## ***Rezoning Petition Review***

**Date of Review:** February 22, 2021 (***Revised March 22, 2021***)

**Rezoning Petition #:** 21-025

**Location of Property:** Approximately 13.05 acres located along the north and south sides of Wallace Lane and east of the East Independence Expwy.

RZ-1.0

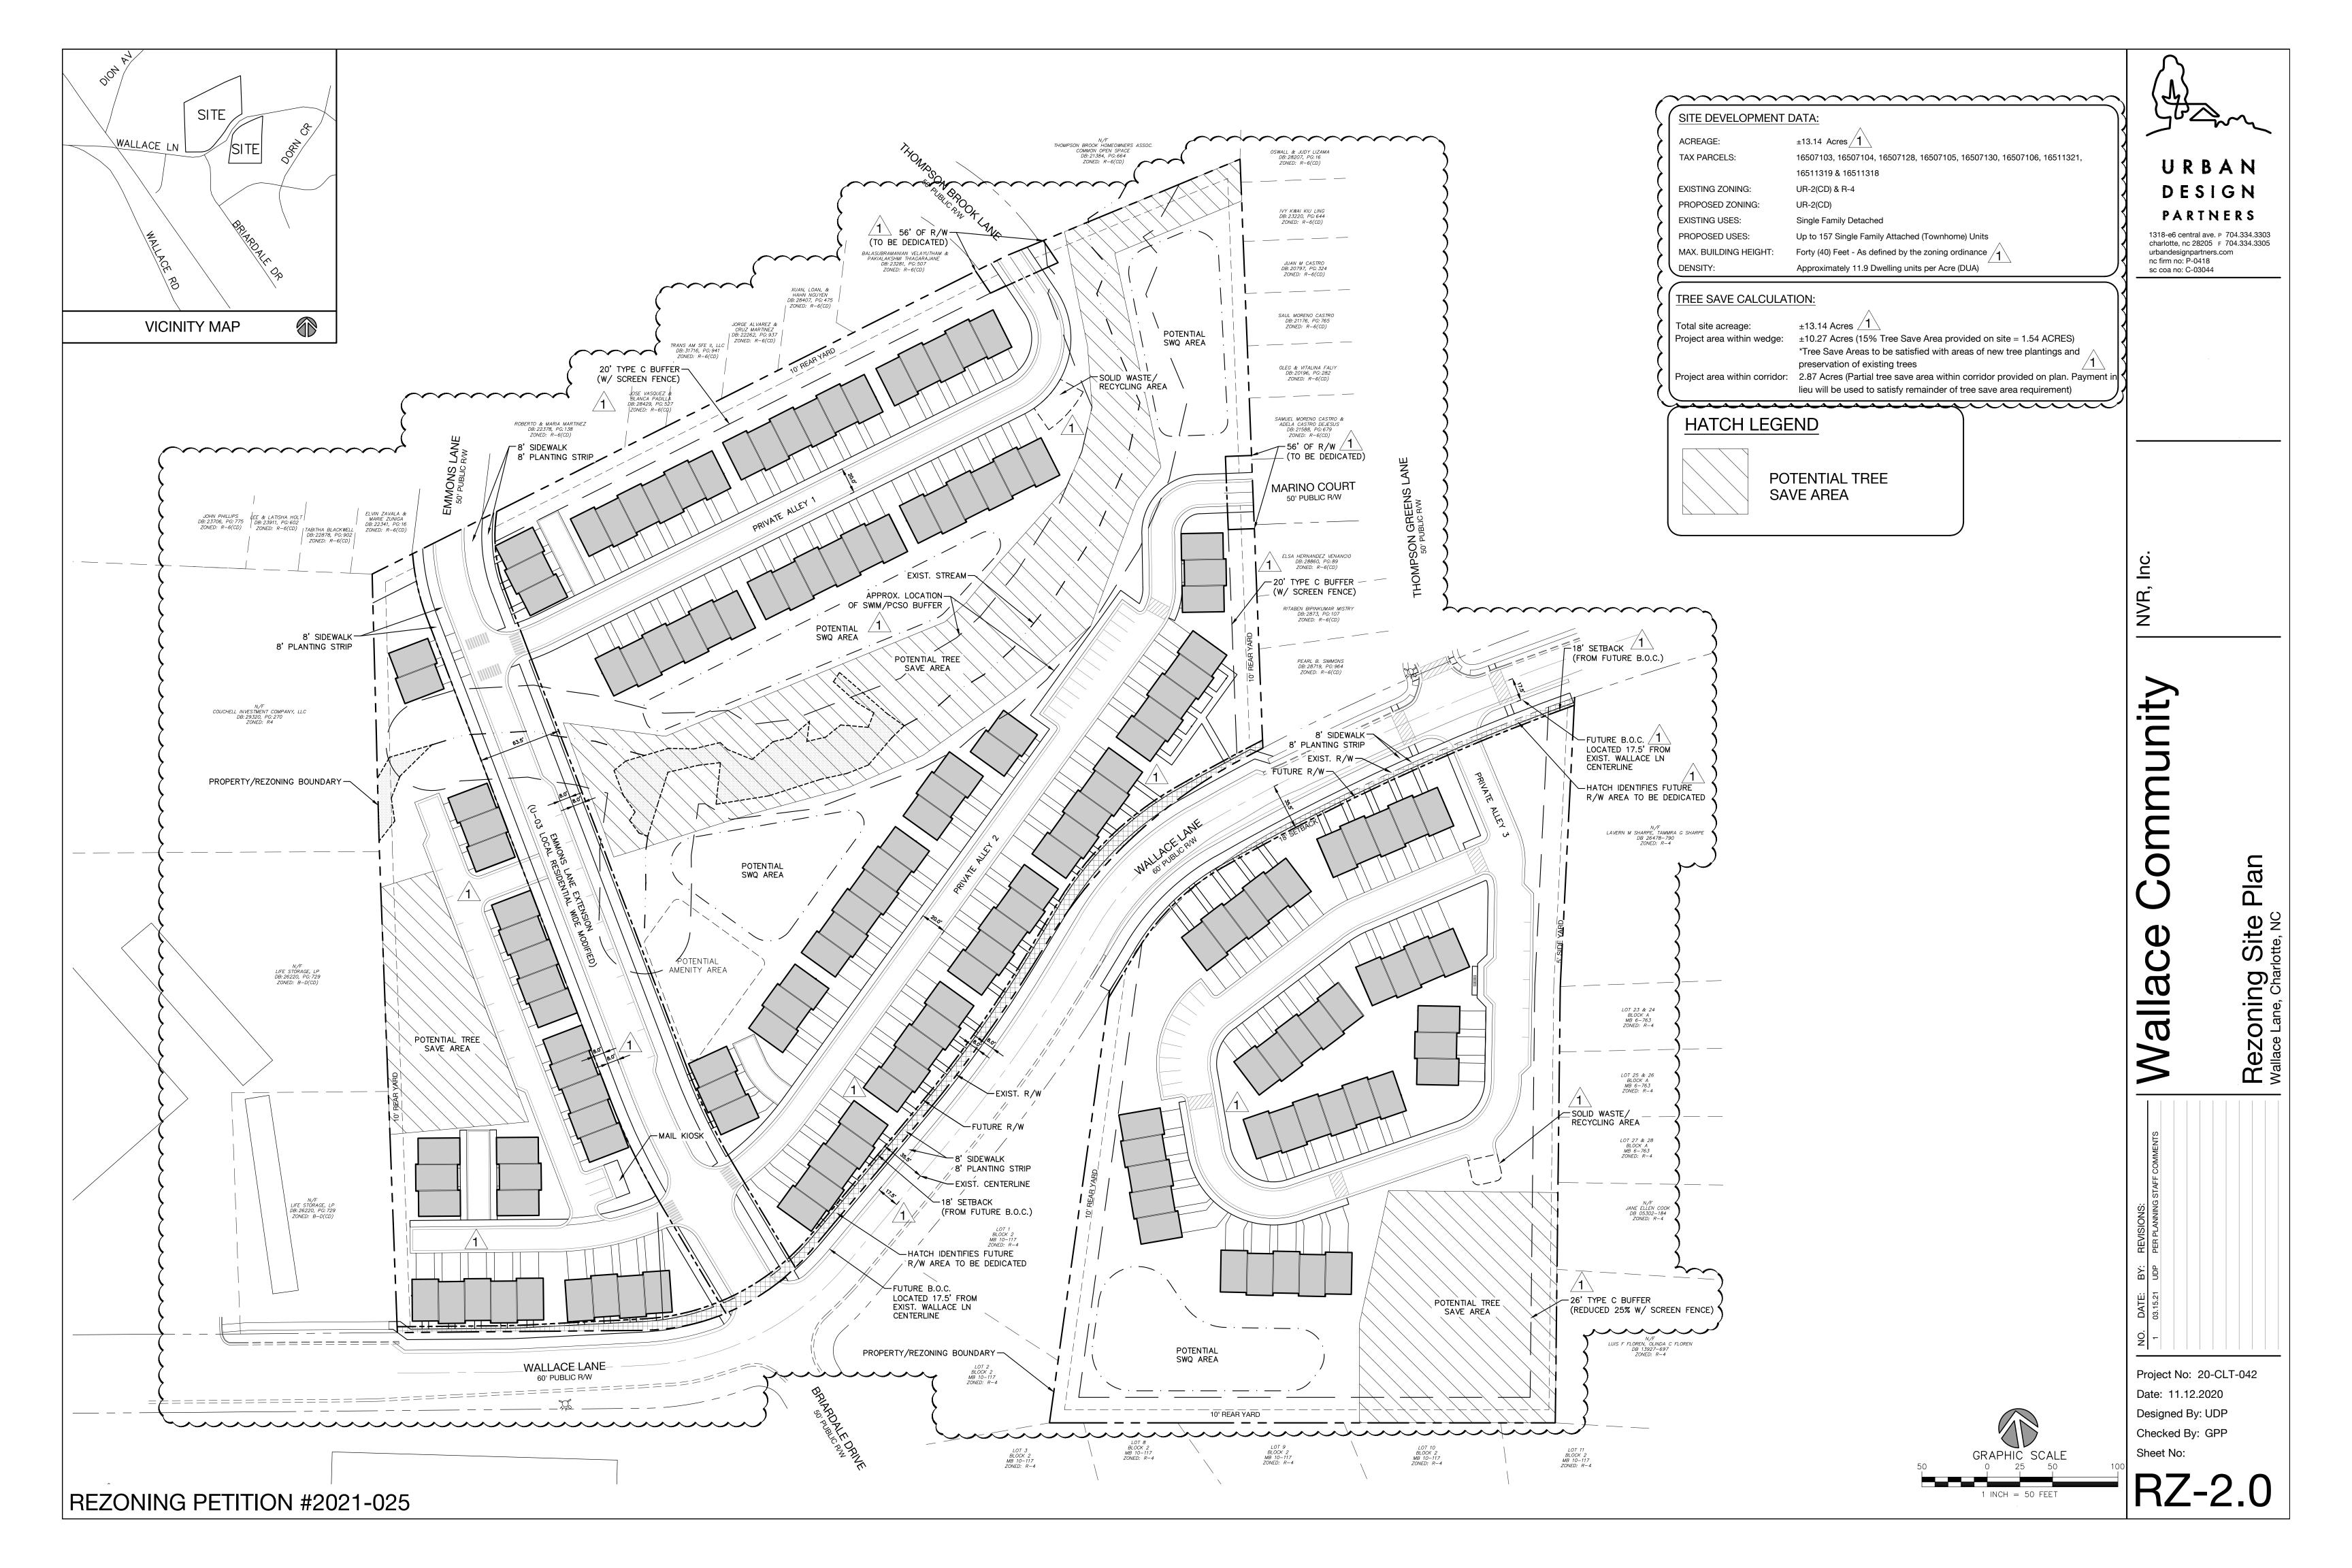
Rezoning sheet RZ-2.0 indicates an existing stream on site. Please note perennial and intermittent streams require SWIM/PCSO Buffers. Please include the following note under Environmental Features:

- *Development within any SWIM/PCSO Buffer shall be coordinated with and subject to approval by Charlotte-Mecklenburg Storm Water Services and mitigated if required by City ordinance. Petitioner acknowledges intermittent/perennial stream delineation reports are subject to review and approval upon submission of development plans for permitting and are not approved with rezoning decisions.*
